OXFORDSHIRE COUNTY COUNCIL'S RESPONSE TO CONSULTATION ON THE FOLLOWING DEVELOPMENT PROPOSAL

Application no: 22/00747/OUT

Proposal: Outline planning application for the development of up to 370 homes, public open space (including play areas and woodland planting), sports pitches and pavilion, drainage and engineering works, with all matters reserved (appearance, landscaping, layout and scale) except for vehicular and emergency accesses to Bicester Road.

Transport Schedule

Appendix C – Vehicle Tracking

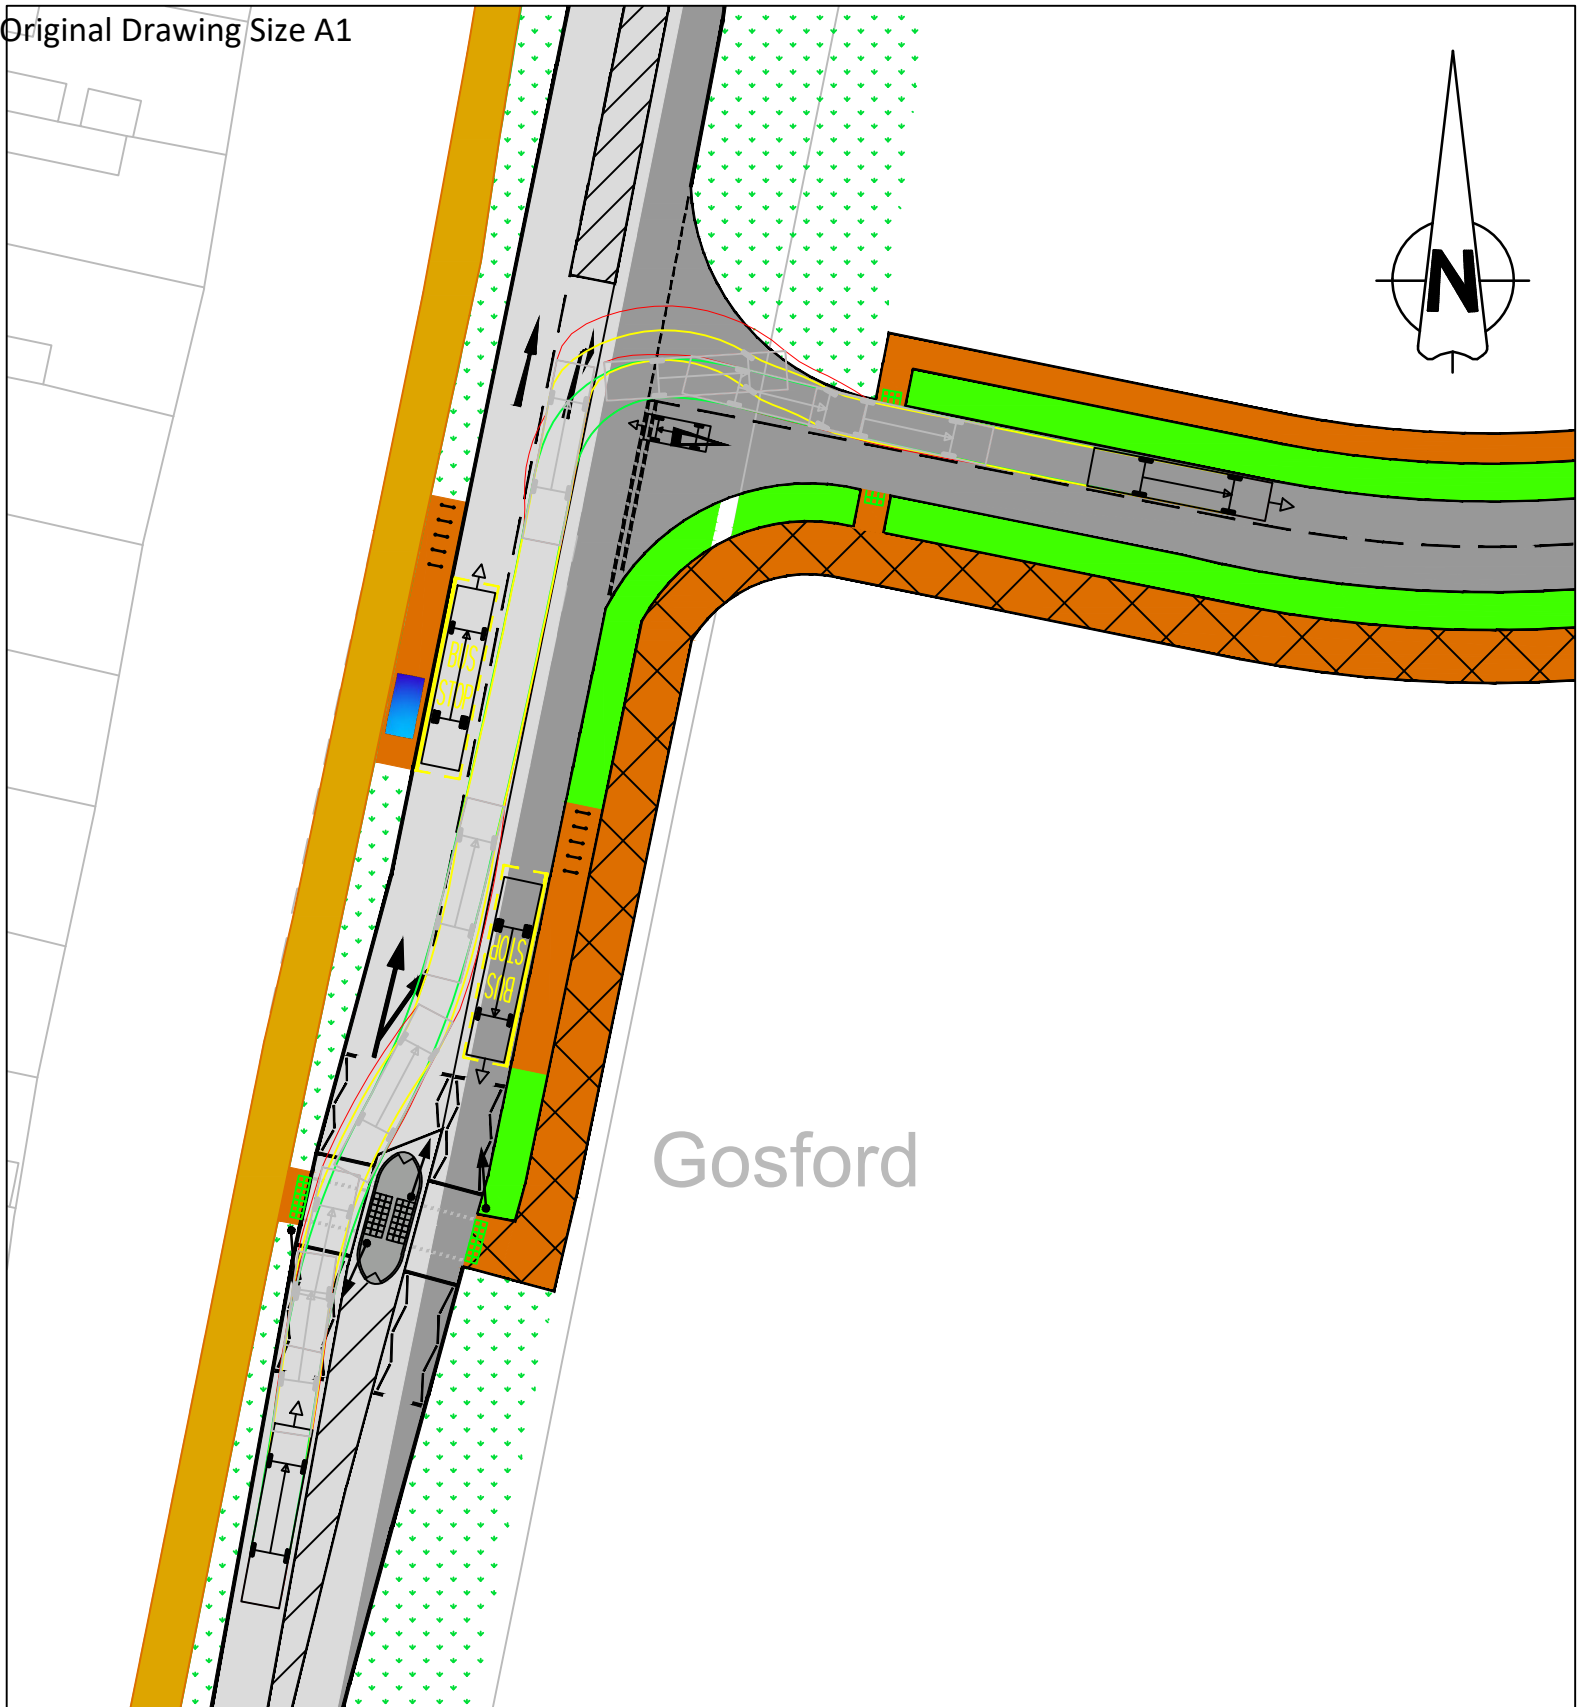
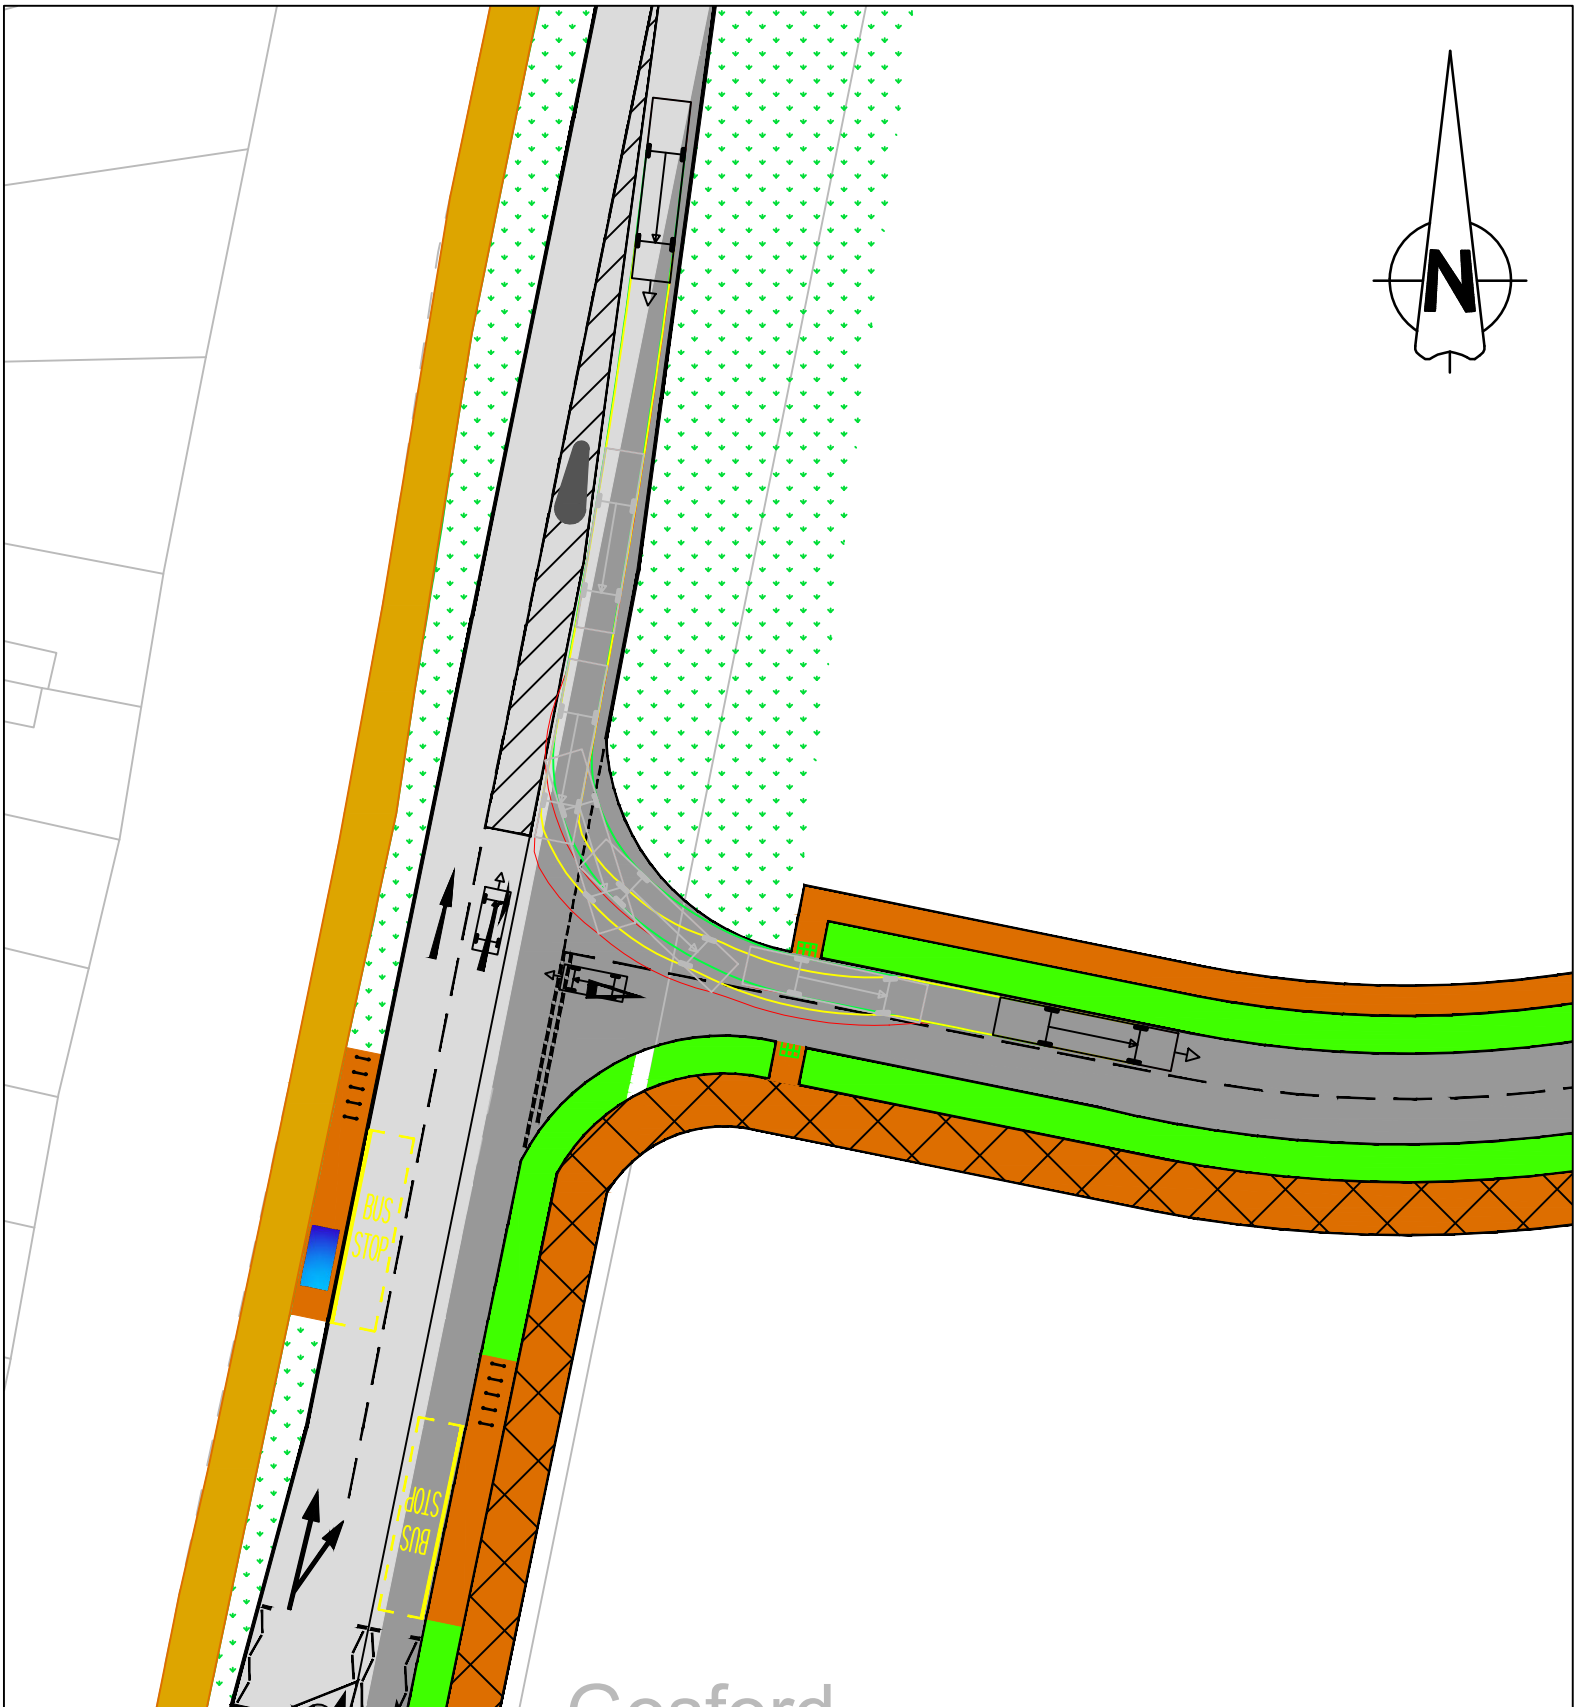
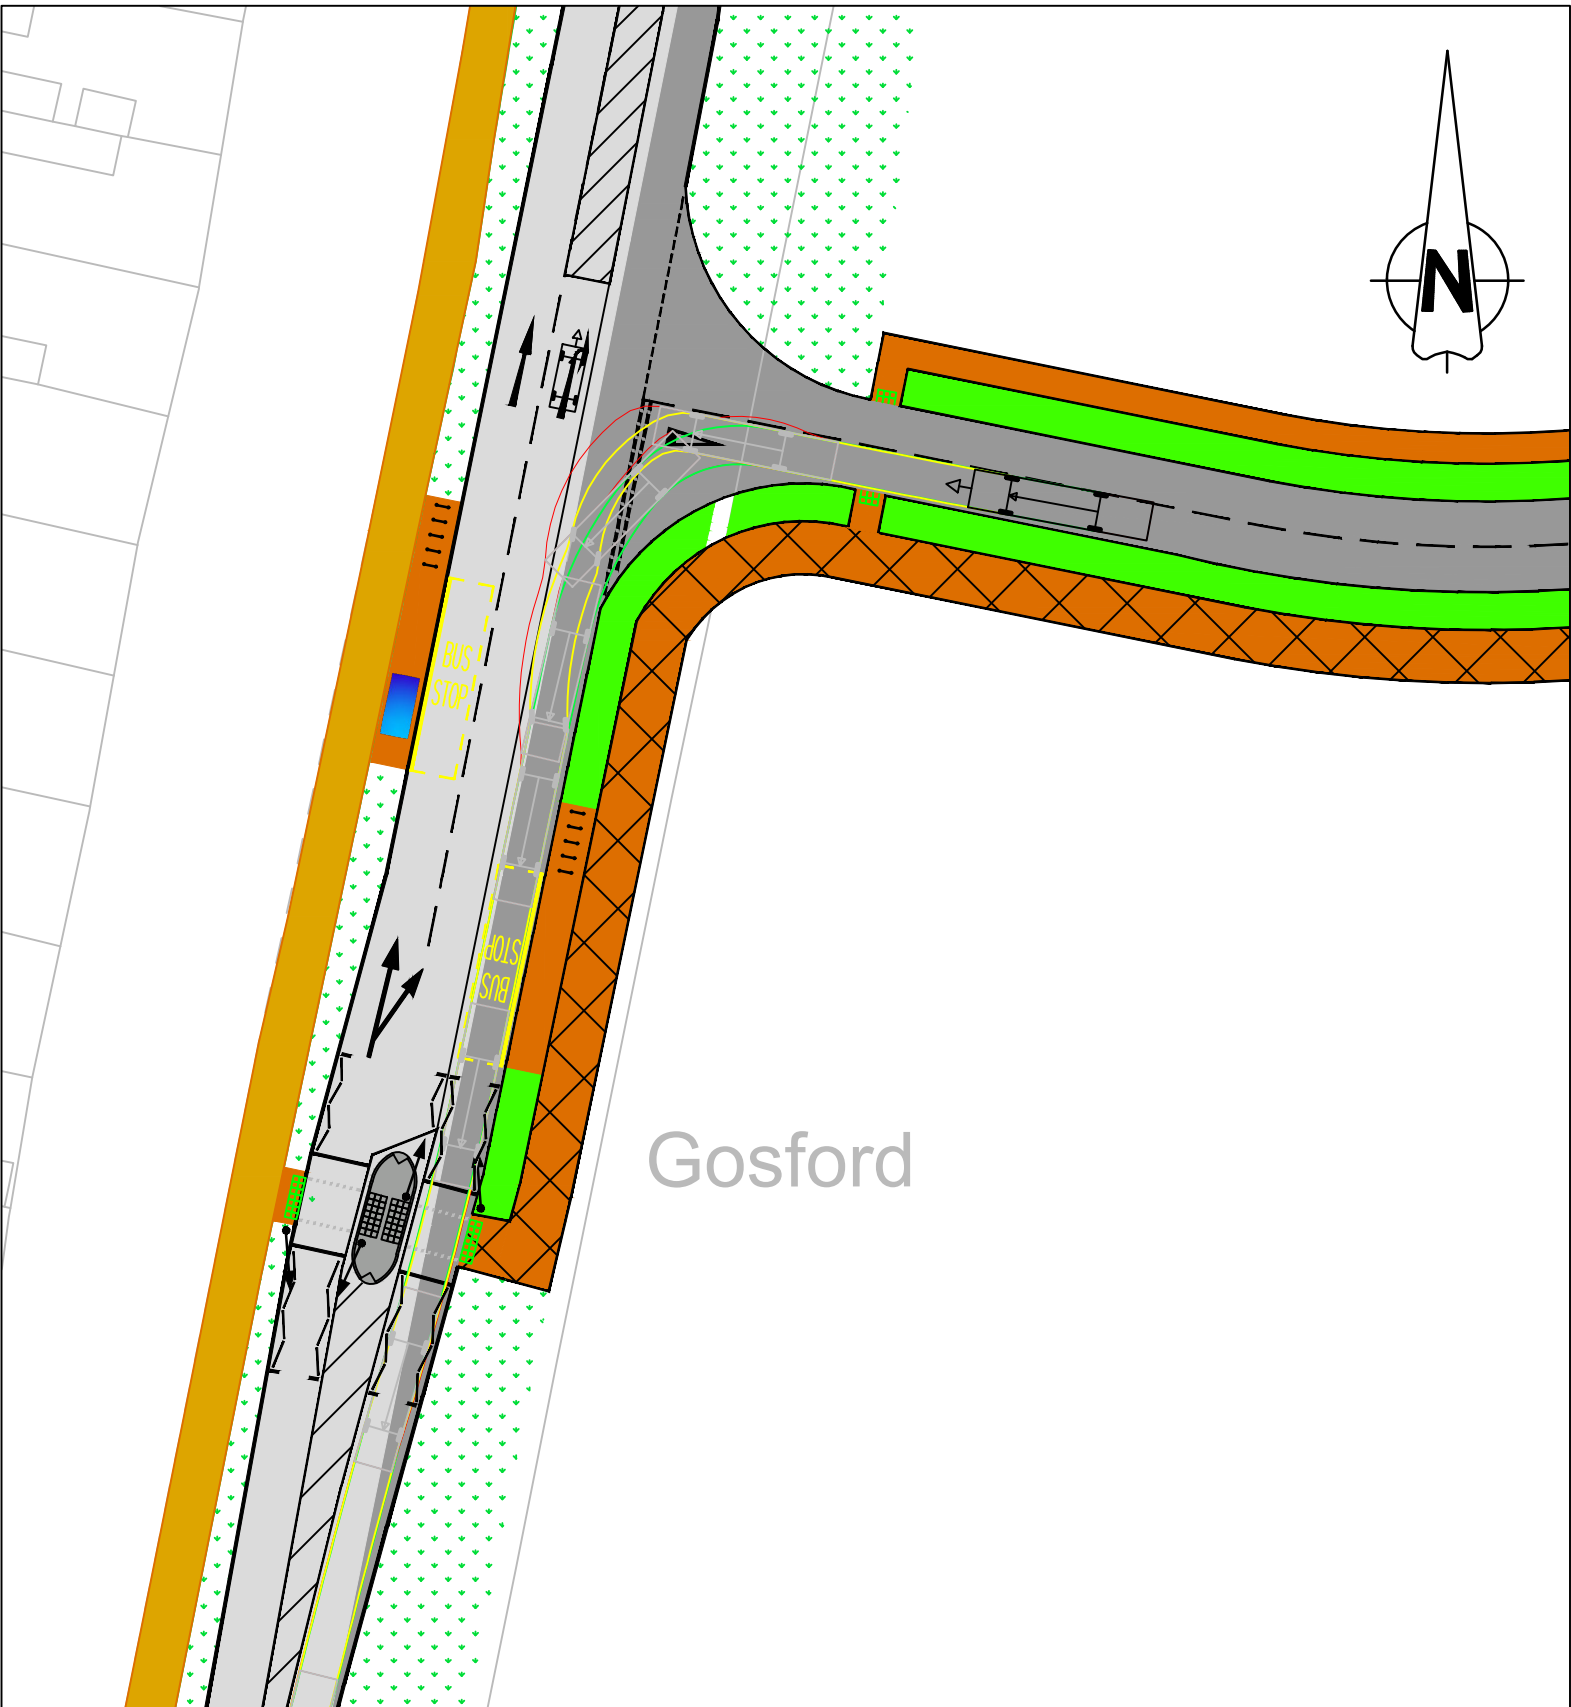
Para 3.5 acknowledges that the swept path drawing exercise was excluded in the previous submission. This has now been appended to the TN, reviewing which I note that the left-out manoeuvres cannot be safely completed in event of waiting right turning vehicles. To address this, it is suggested that the first 15m of the access need be widened to 5.5m. Alternatively, amendments to the access arrangement that take the form of a localized widening of the carriageway to ensure such vehicles can safely egress. **(Reason for objection)**
